Recommendation Report for Planning Permission for Works or Extension to a Dwelling

REF NO: A/19/22/HH

LOCATION: 73 Lloyd Goring Close
Angmering
BN16 4LQ

PROPOSAL: Single storey side/front extension.

Drawing No 213091/ 02

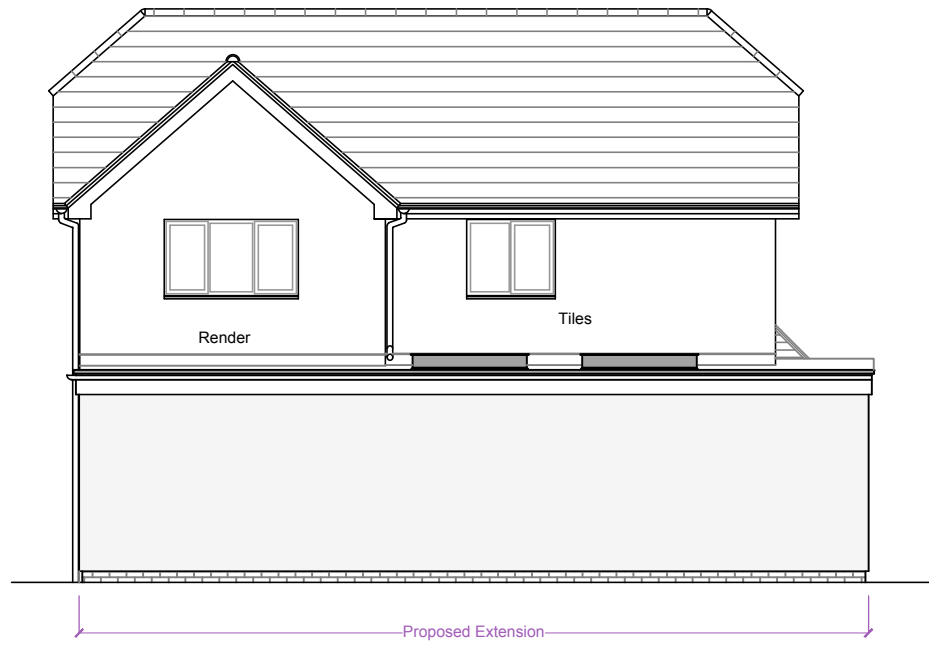
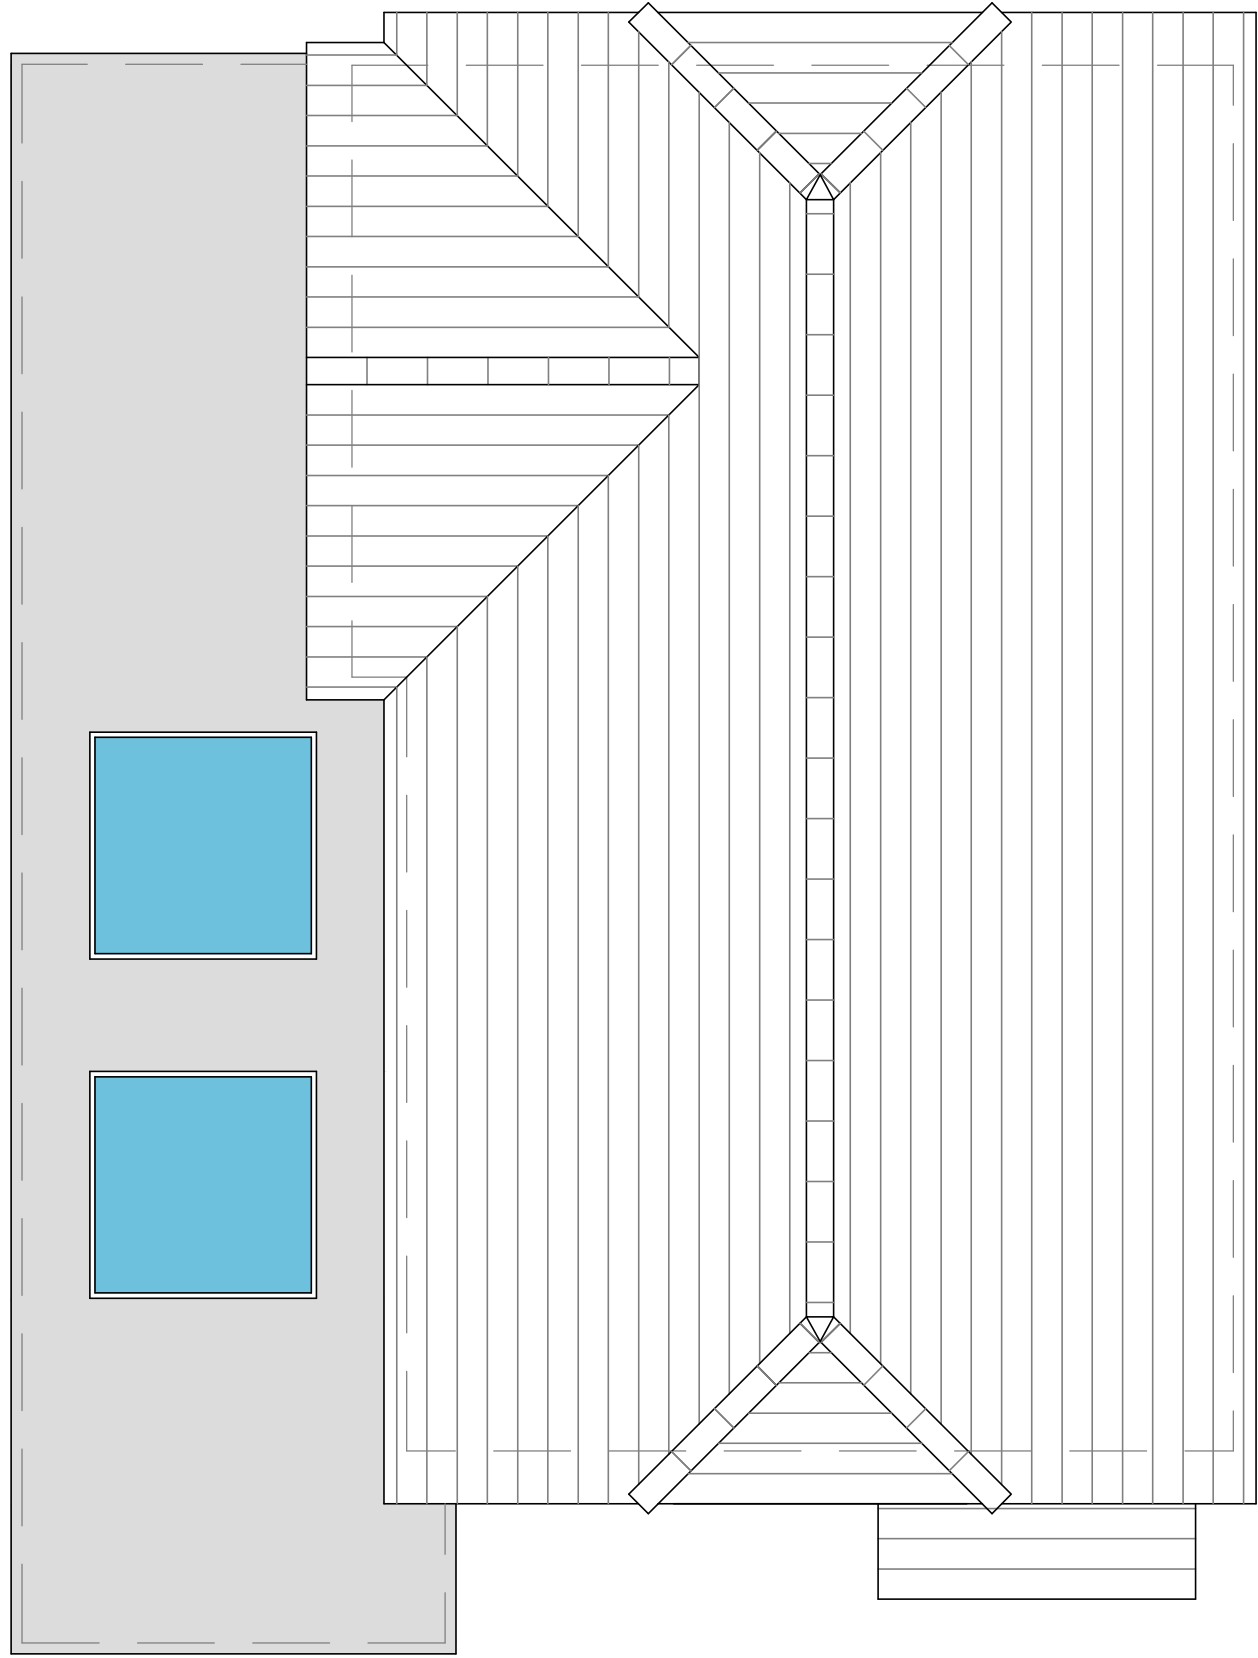
The proposed single storey side extension extends 10.5m across and 2.8m off of the eastern elevation at a peak height of 3m with eaves at 2.8m. The roof of the proposal features 2 No. rooflights and a shallow pitch flat roof design. The proposal is substantial in length but is moderate in overall scale relative to the host dwelling and as such, it is considered subservient to the host property.

The host dwelling features three different external wall materials, facing brickwork, hanging tiles and render, all three of which can be found on the east elevation. The proposed wall materials for the side extension are to be render over facing brick plinth which is considered appropriate. The shallow pitch flat roof design consists of felt, which is considered acceptable. All other materials within the proposal are to match and considered appropriate.

The 2 No. rooflights featured in the proposal will provide positive amenity benefits for the host dwelling by giving access to natural light. The rooflights are considered appropriate in design and a positive addition to the proposal.

North Elevation –
(Front) 1:100

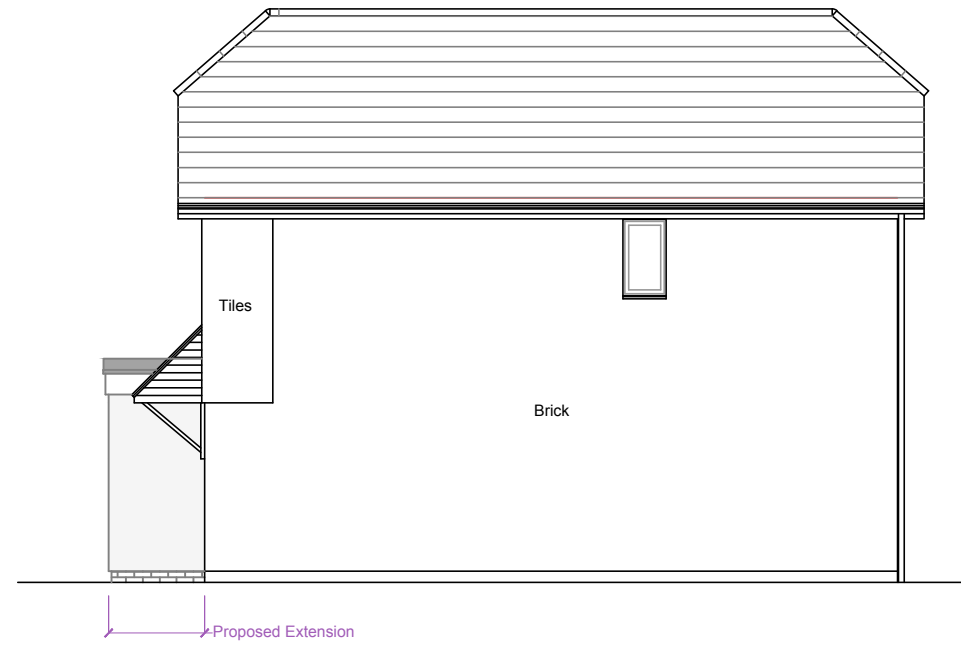
The host dwelling is a corner property with the North and East elevations fronting the street. As such, the proposal will be visible from the street. Views from the side will be limited due to the single storey nature of the proposal and fenced boundary treatment surrounding the sides and rear of the property. The views from the front will be prominent. However, the design of the proposal is acceptable and there are similar, albeit smaller, examples of side extensions in the locality and as such, there will be no significantly adverse impact on the street scene.

The proposal features a set of rear glass doors that look out to the rear of the garden. These will not give rise to any adverse impacts by way of overlooking.
